ROBERT J. BRACKEN
ENGINEER + SURVEYOR

August 20, 2020

REF: Foundation wall inspection
31 Elsie Buchanan Ln.
Broadway, NC 27505
Lamco Homes, Owner

DESIGN PROFESSIONAL INSPECTION FORM

Footing & Foundation Detail not to scale

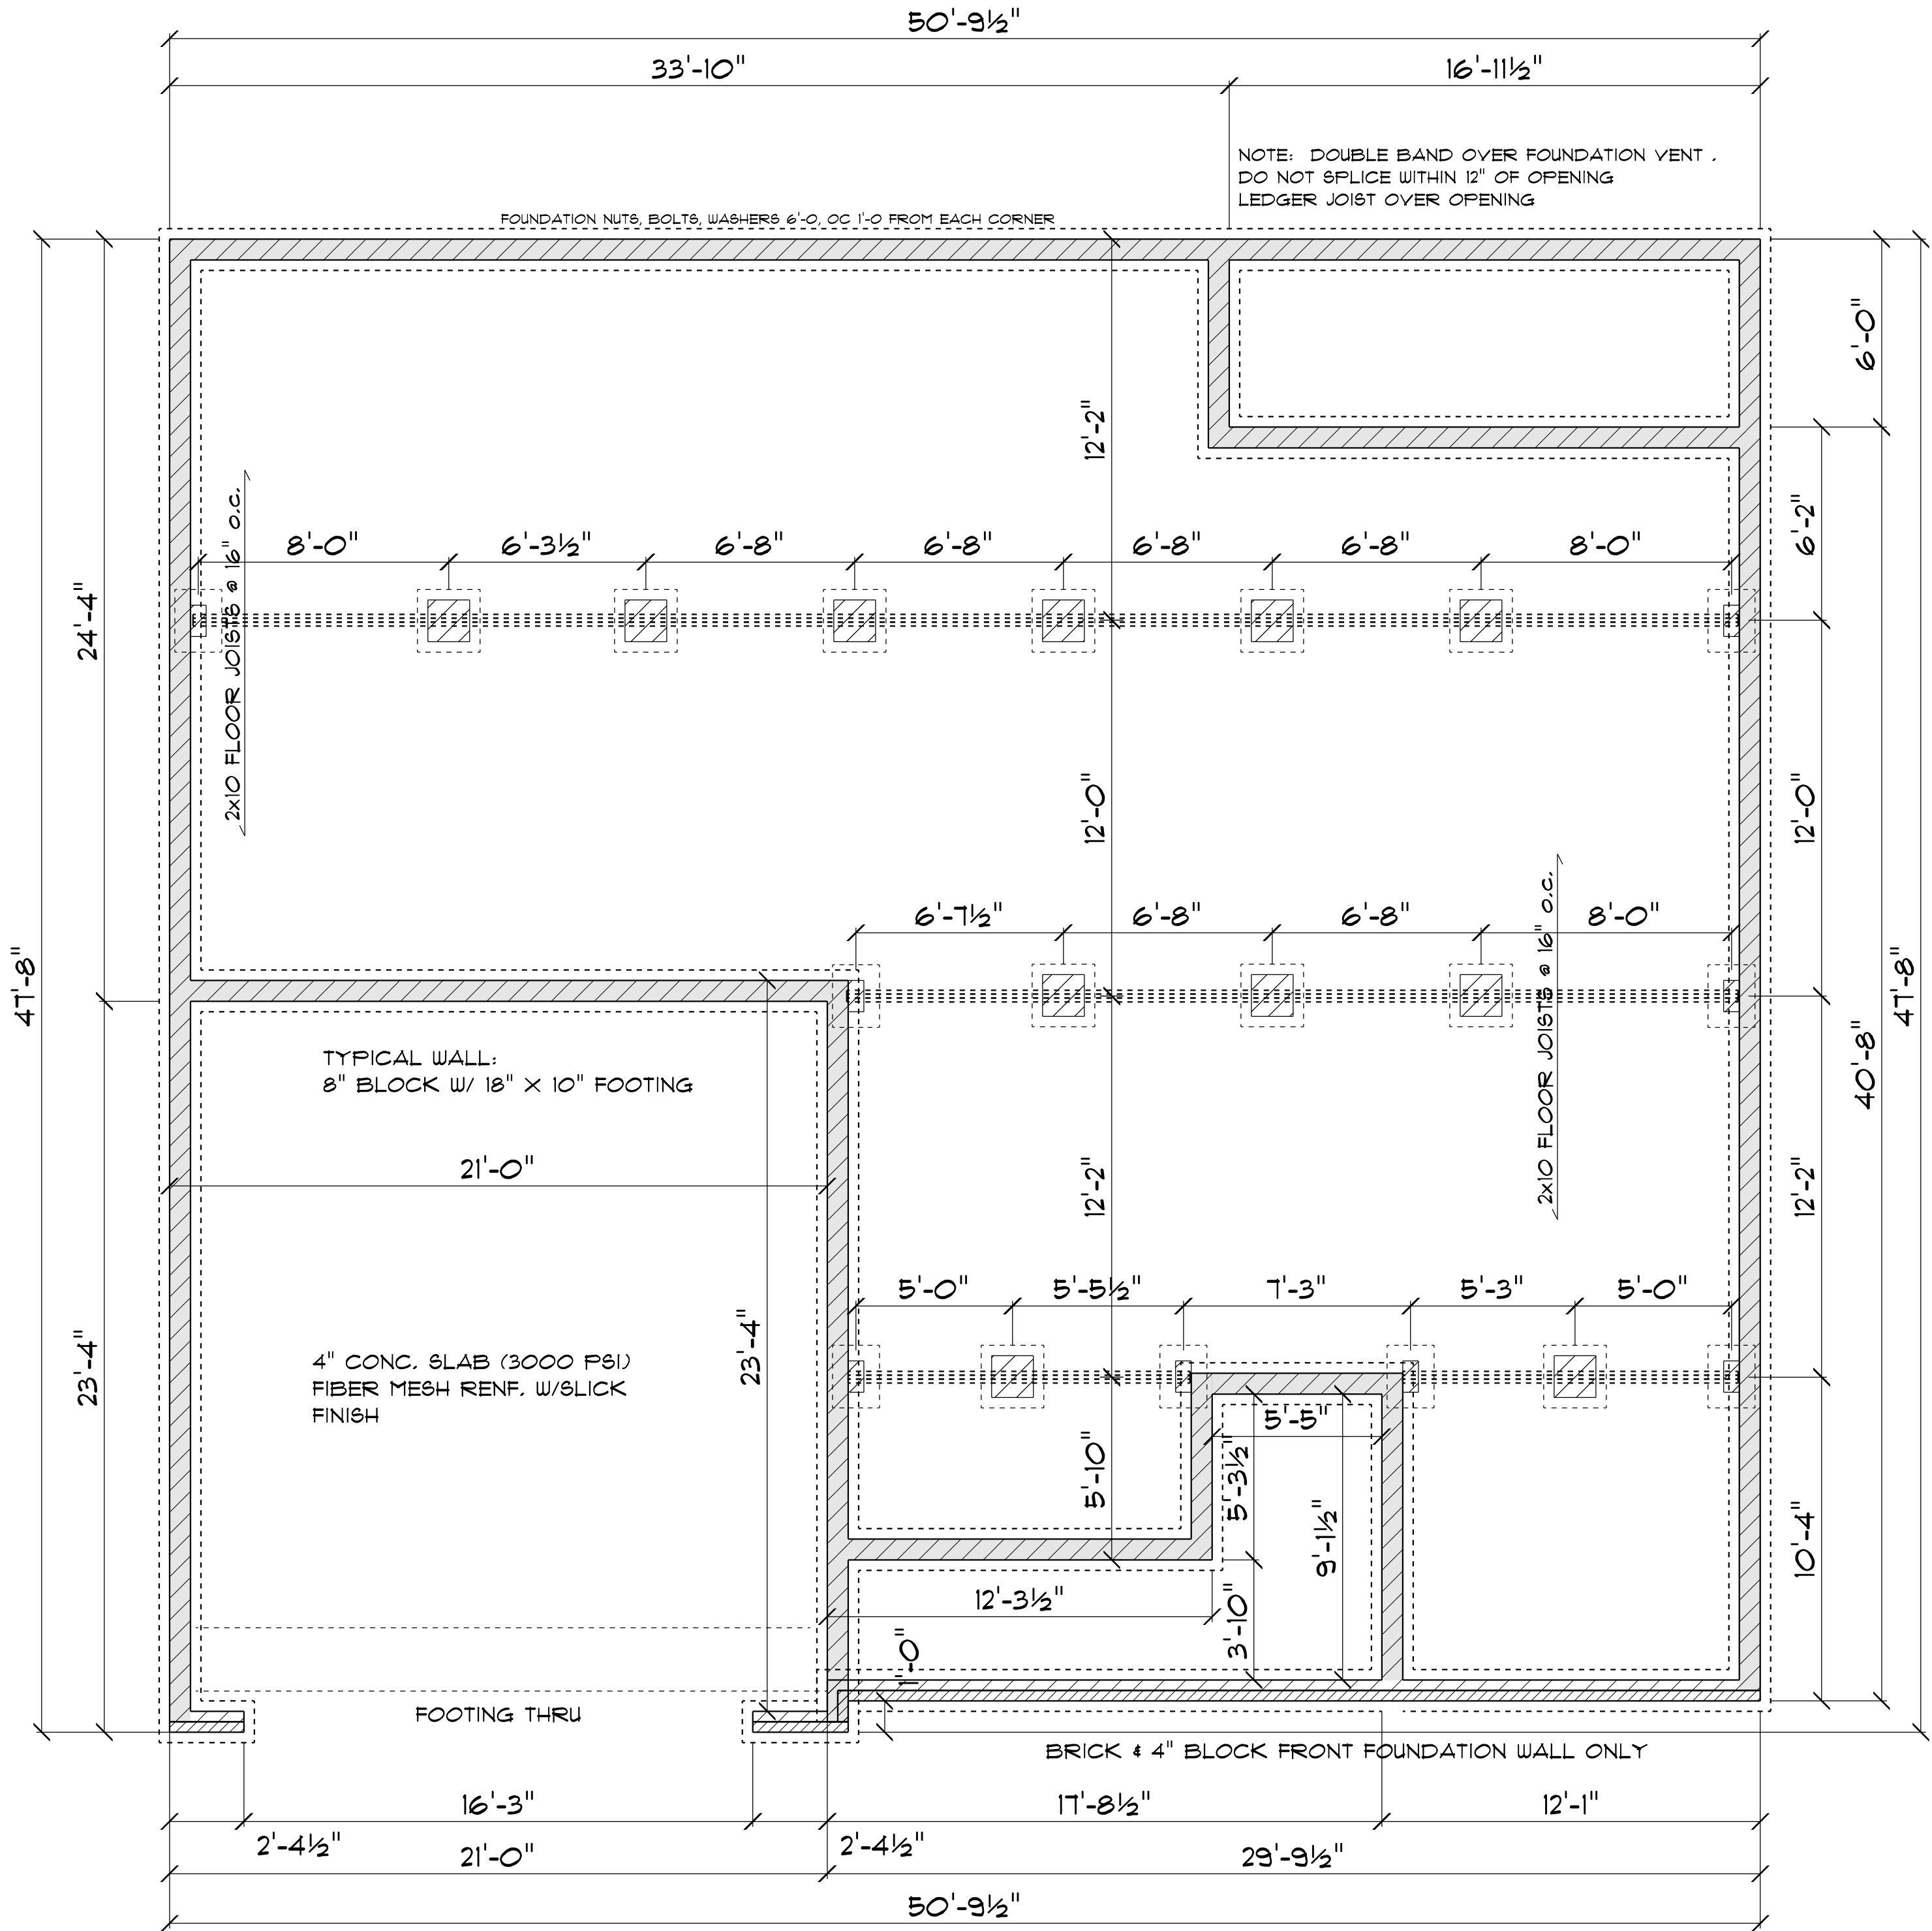
I made an onsite visit to the above referenced Residential site on August 17 , 2020. The purpose of the visit was to examine the placement of a 12" block foundation wall on a footing prepared for an 8" block wall, which allowed approximately 1"of projection. I have no problem with the lack of projection because the amount of vertical down force on the edge of the 12" block is not enough to shear off the footing's edge. The condition is safe and will support the applied loads as specified in the North Carolina Residential Building Code, 2018,ed.without failure.
